MECKLENBURG COUNTY
Land Use & Environmental Services Agency

MEMORANDUM

Subject: Rezoning Petition Comments

2022-051: 12300 Sam Neely

CONCEPT PLAN - SF ATTACHED

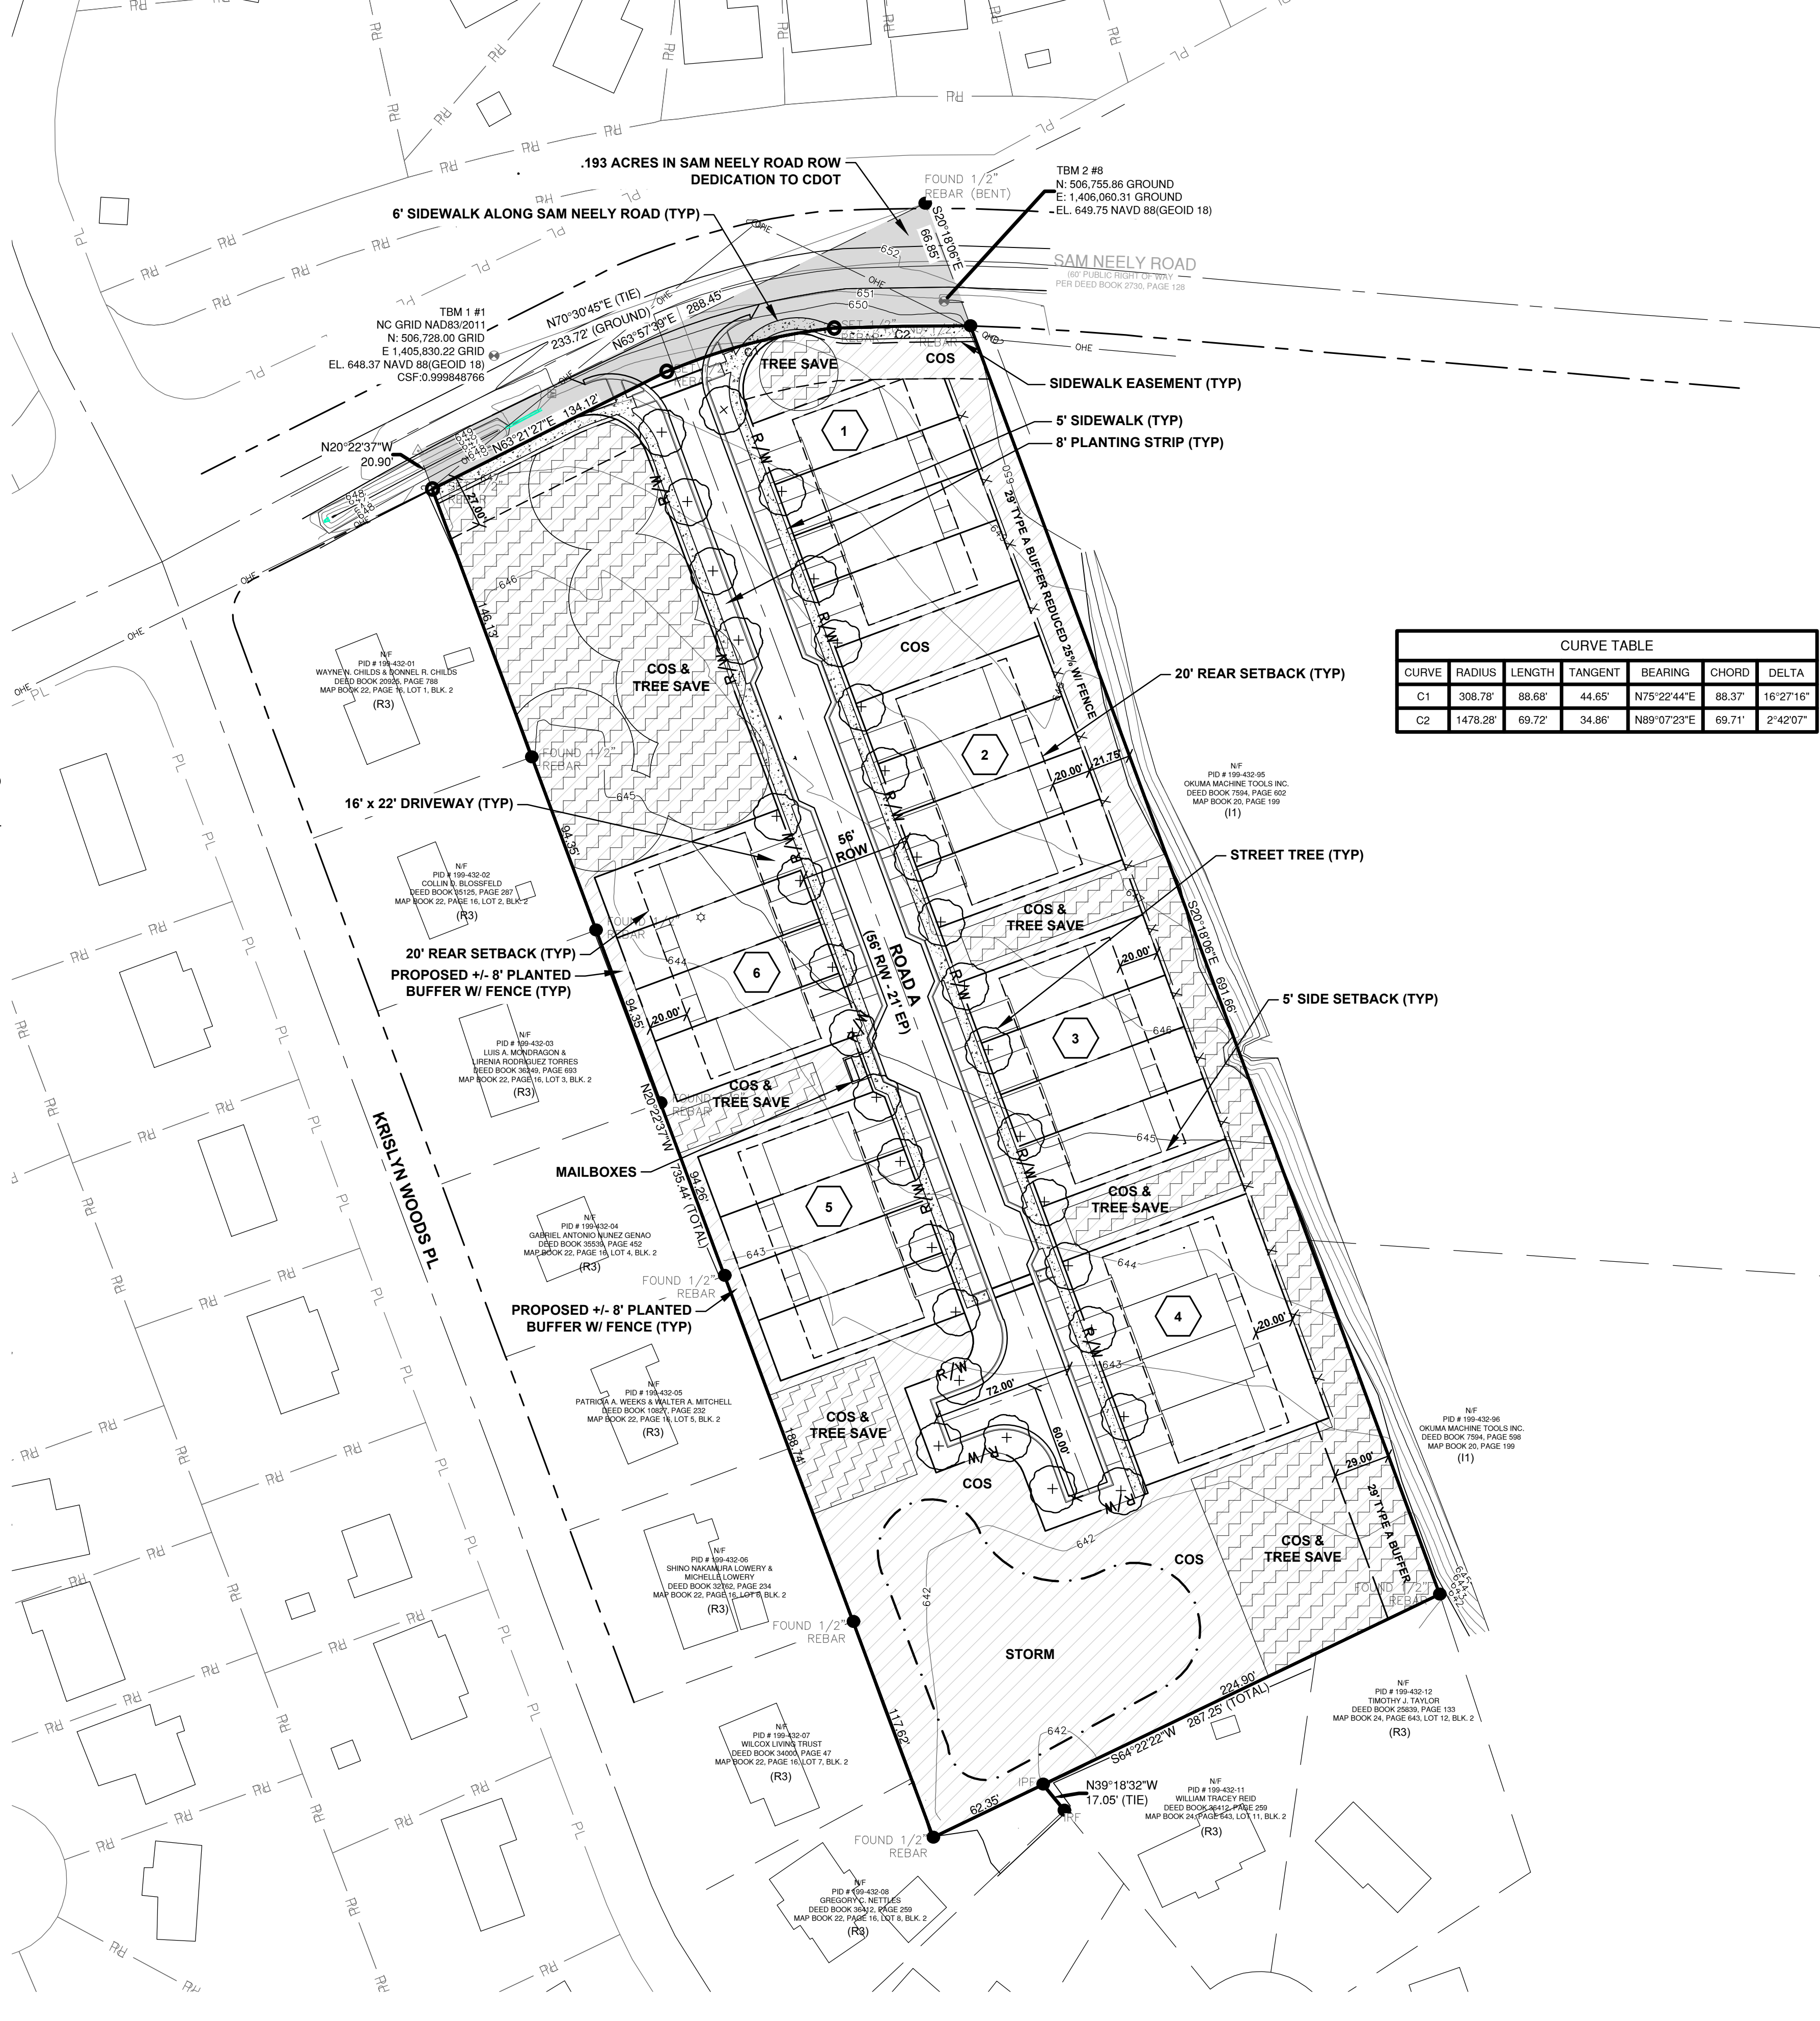
Air Quality Comments: The proposed development is planned to serve a multifamily/community/office group and to have vehicle parking greater than or equal to 20 spaces. Mecklenburg County Air Quality recommends that the proposed development be constructed with at least 10% EV-ready parking spaces. EV-ready spaces are those that have pre-installed electrical panel capacity with a dedicated circuit, raceway with conduit, and either a junction box or 240V outlet.

Information from property records does not indicate the current use of oil heat, but since records indicate structures were built in 1962, the property may contain an underground or above ground fuel oil storage tank. Any existing tank and its contents should be removed, following applicable NCDEQ guidance, prior to any demolition or grading activity.
